KIRKLEES METROPOLITAN COUNCIL INVESTMENT & REGENERATION SERVICE

Reference No:	2024/62/93554/W
Site Address:	5, Norcross Avenue, Oakes, Huddersfield, HD3 4FP
Description:	Erection of two storey side and rear extension
Recommending Officer:	Molly Storer

HOUSEHOLDER DELEGATED REPORT

Application Number	2024/93554
Location	5, Norcross Avenue, Oakes, Huddersfield, HD3 4FP
Proposal	Erection of a two storey side and rear extension.
Publicity end date	14 th February 2025
Number of representations received	One – see representations section.
Kirklees Local Plan Allocation/Designation	Unallocated in the Kirklees Local Plan
Extension to Time (EoT)	Yes EoT Date: 20 th February 2025
Recommendation	Conditional Full Permission

Drawing
Proposed Elevations

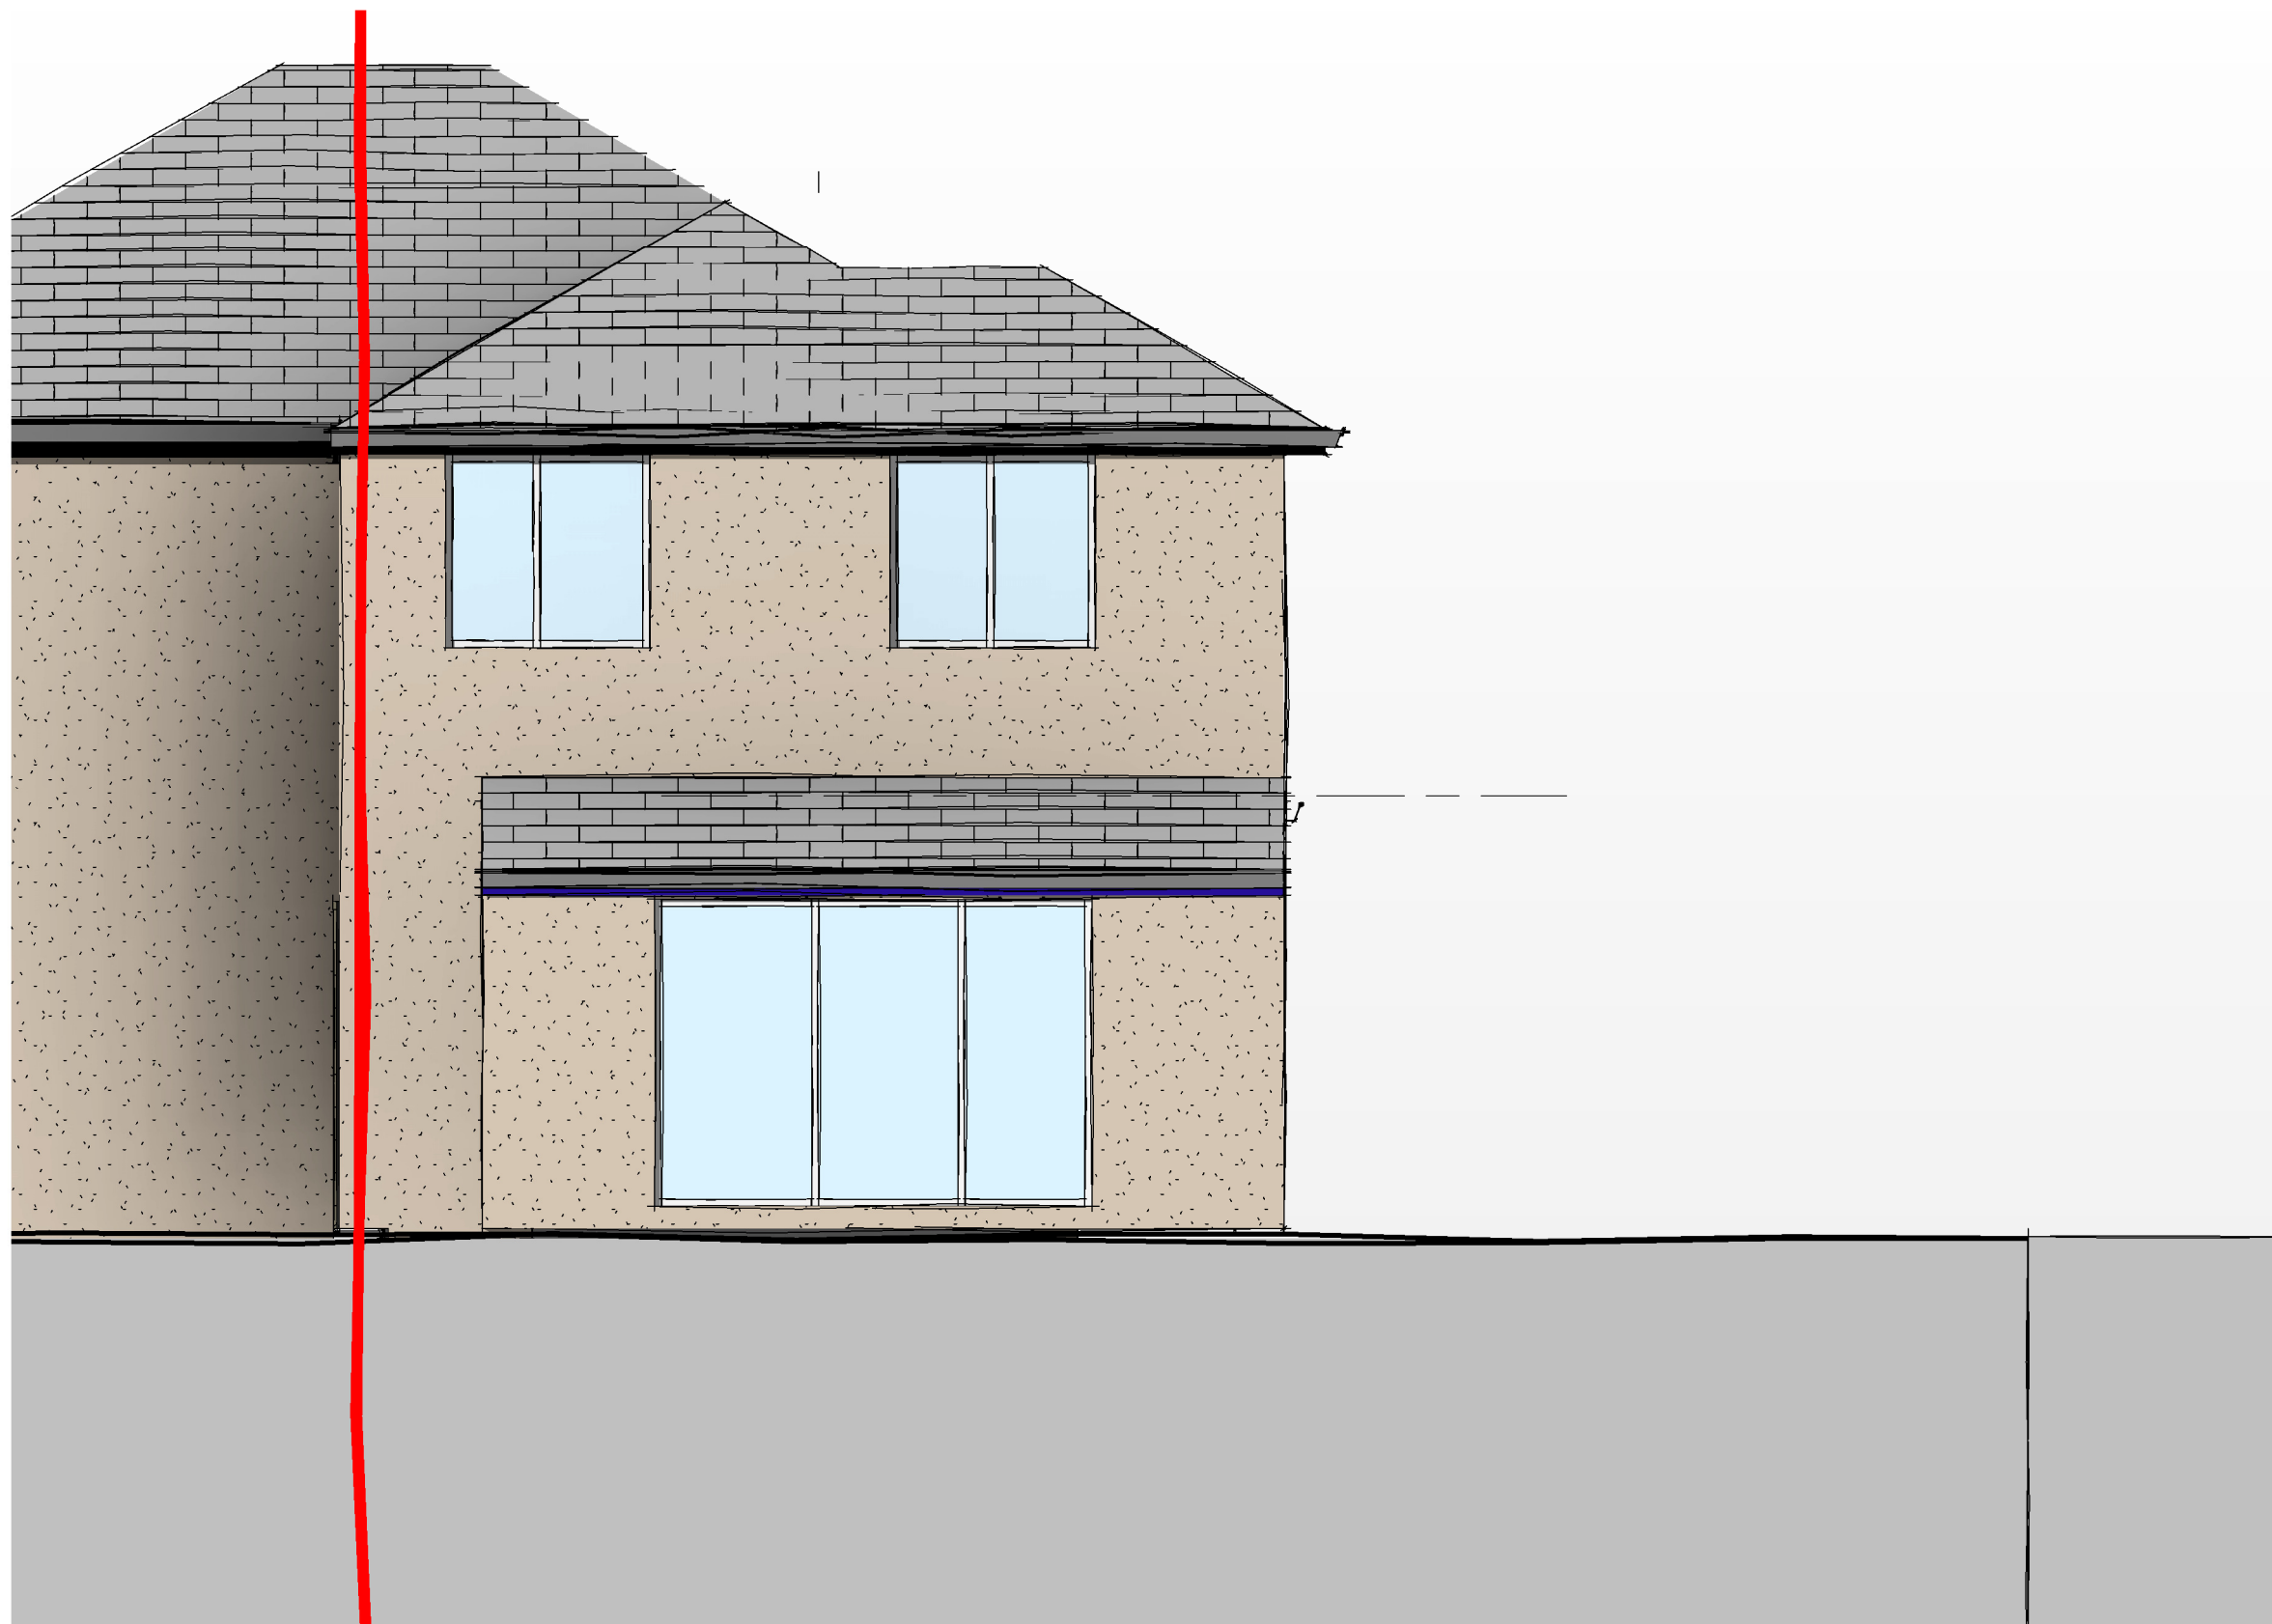
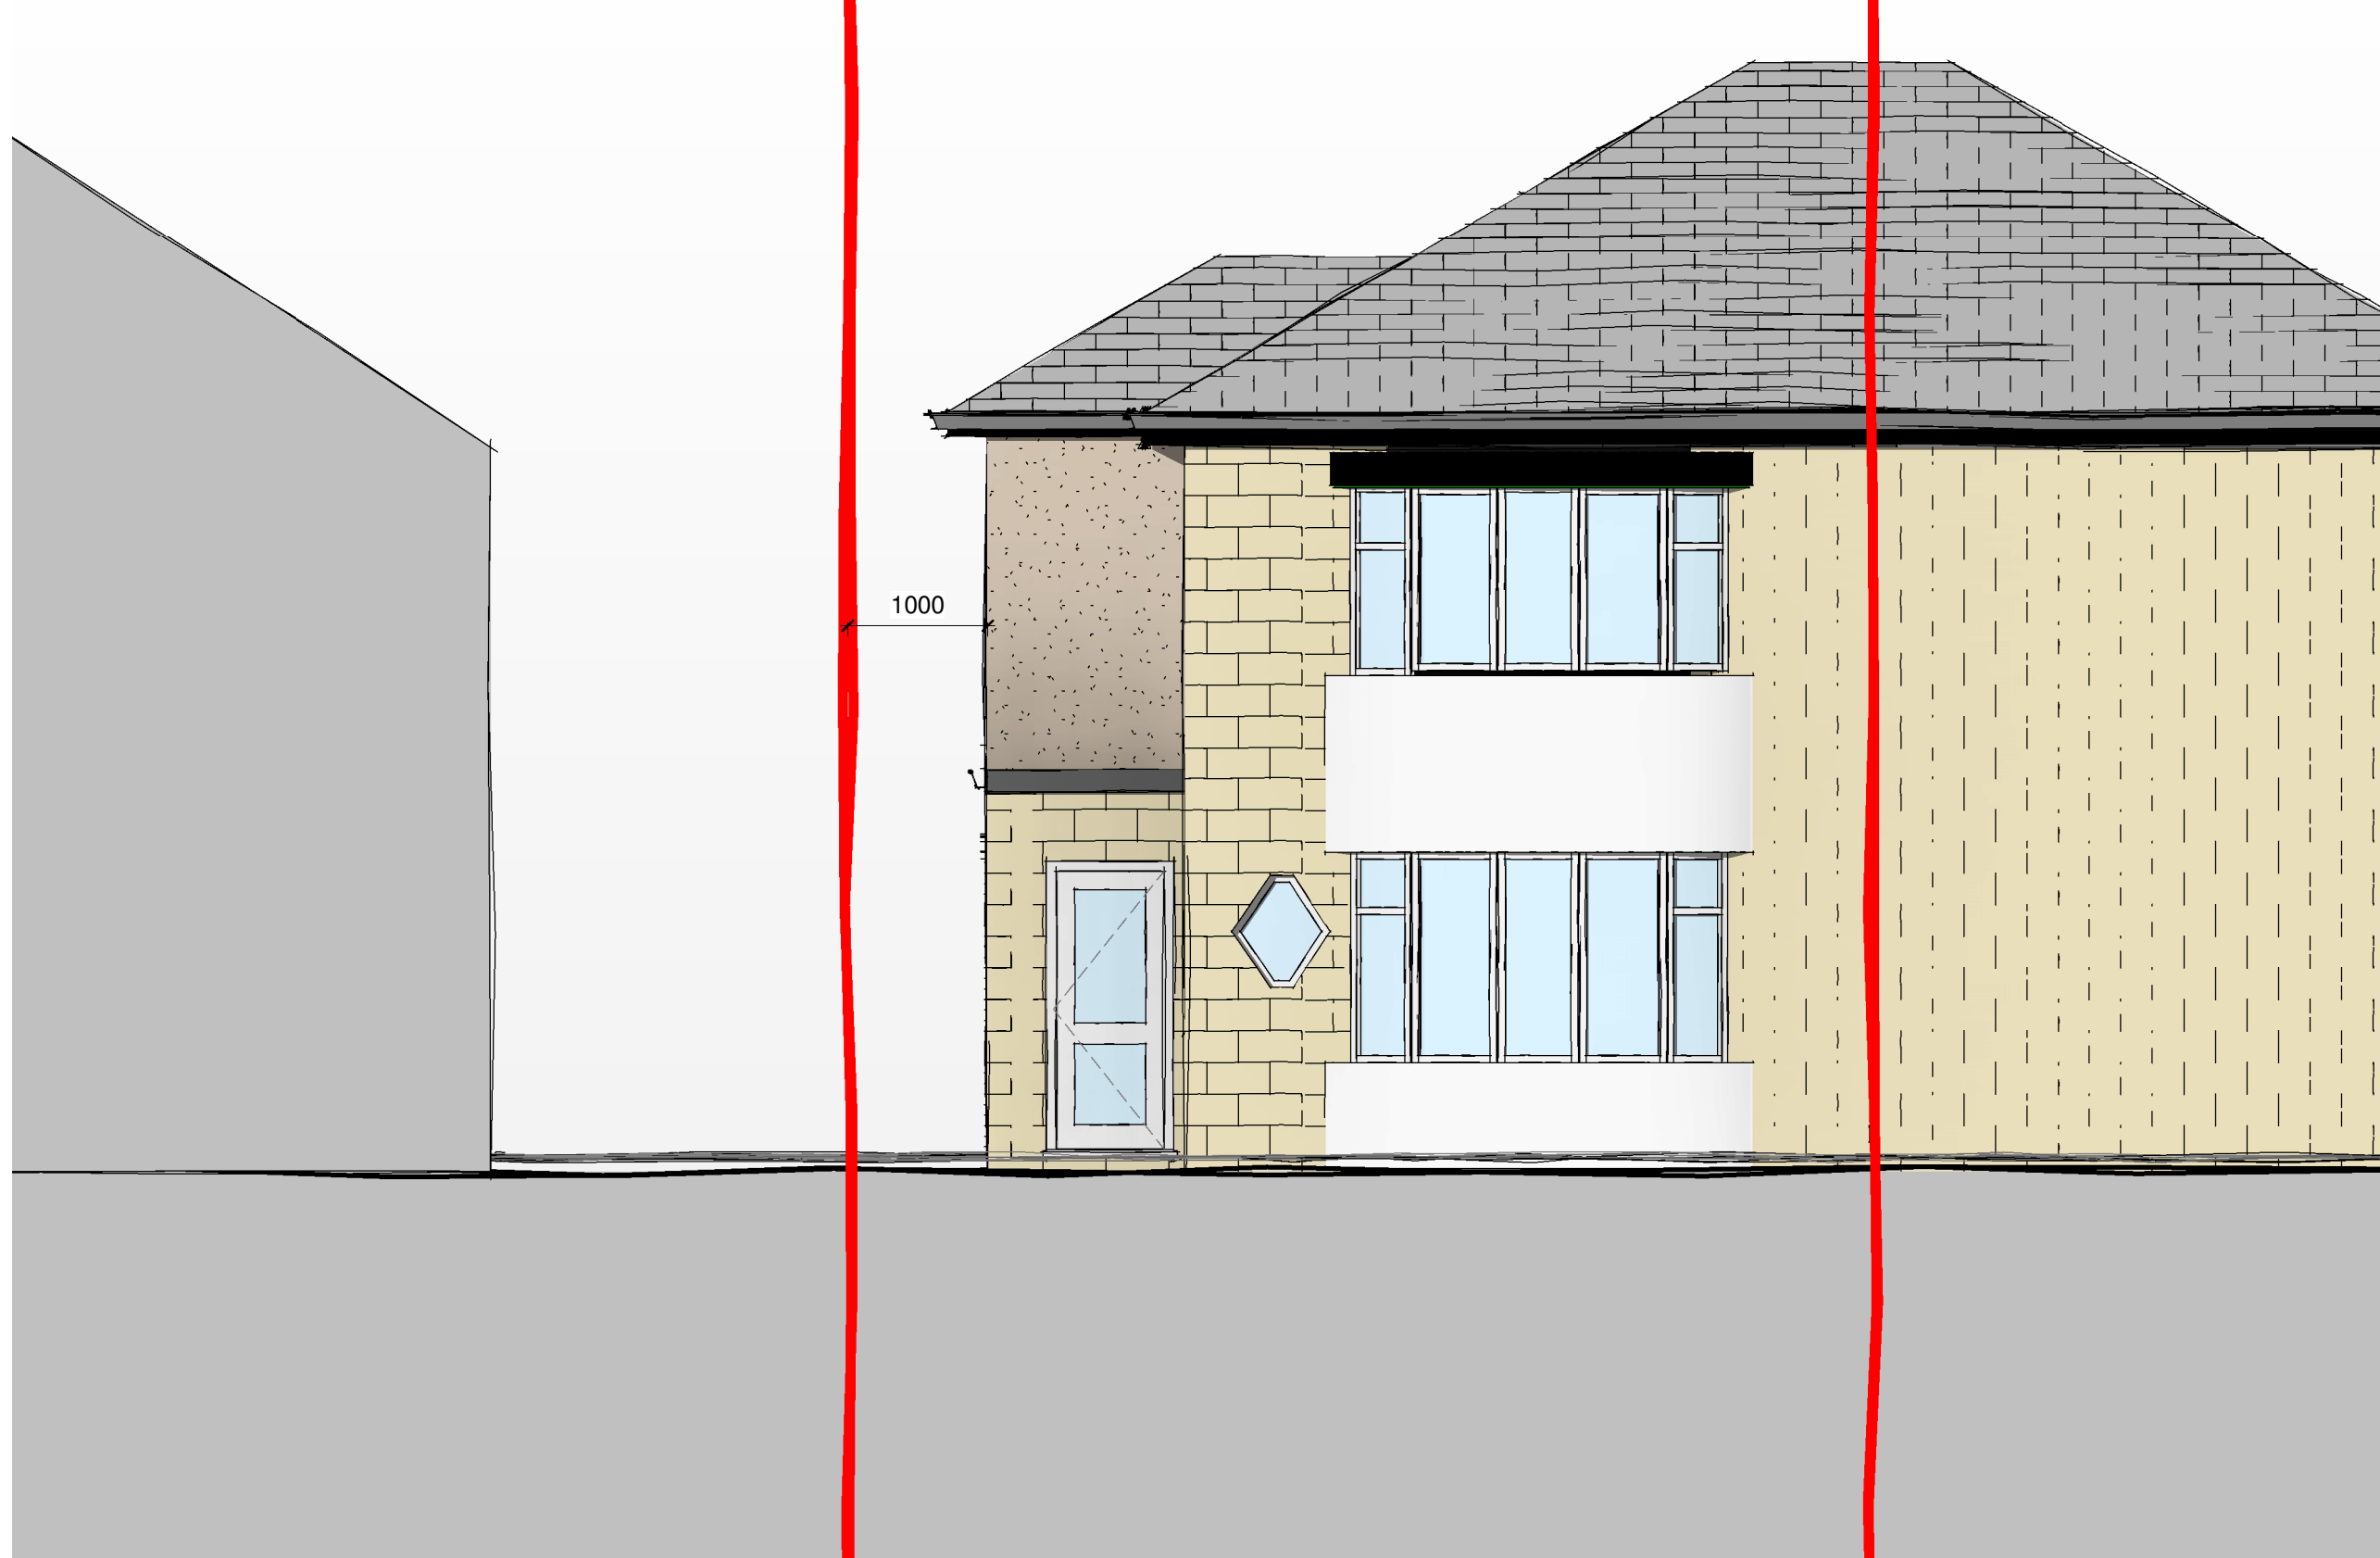
The scheme proposed in this application showed the first-floor element of the rear extension built on the boundary with No.7 whereas the amended plans for this application show the first floor element to be set off the boundary by 1m. The agent was contacted to show the 45-degree line from the extension to the nearest habitable room window at number 7 as the SPD states 'When assessing the impact of overshadowing on neighbouring properties, the council will, as a starting point, have regard to the 45° guidelines. A line will be drawn from the midpoint in the nearest habitable room window of the adjacent property, at an angle of 45°, across the proposed extension. The extent to which the line infringes upon the proposed extension will indicate the levels of light that may be lost to the neighbouring property.'

Submitted plans from the agent showed that the extension would have an effect on the 45-degree angle by 20cm to the neighbouring habitable room window and regard has to be had for this relationship. It is considered, on balance, that although the 45-degree angle is slightly impinged, due to the orientation of the properties as well as the extension being located to the north of No.7 the sun path is such that more light will be available to No.7. With regards to outlook this is an improved scheme than the refused scheme as space is afforded. Furthermore, there have been no objections received from number 7 in respect of the impact of the extension on their window therefore, given this and that the 45 degree line is only marginally cut in this isolated case this is considered acceptable.

The scheme proposed in this application showed multiple additional windows proposed to the side elevation facing number 3 in both the ground and first

floor. It also showed a two-storey element with a length of 6.7m at a separation distance of 0.75m. The plans for the current application show the majority of these windows to be removed and only a single window included to the side elevation which will be positioned to face onto a blank section of the neighbouring wall. It is also noted glazing which currently directly faces a habitable window at No.3 will be removed and replaced with a blank wall in this position, improving privacy. With regard to the length – part of the side extension has been reduced to single storey and the two storey element will have a length of only 3.3m and the separation distance has been increased to 1m. This is considered to overcome the previous reason for refusal as it is now considered that the extension will not be unduly overbearing and oppressive and would maintain a reasonable level of light to No.3.

This is considered to overcome the previous reason for refusal as it is now considered that No.7 will receive acceptable levels of light, and the extension will not be unduly overbearing or oppressive.
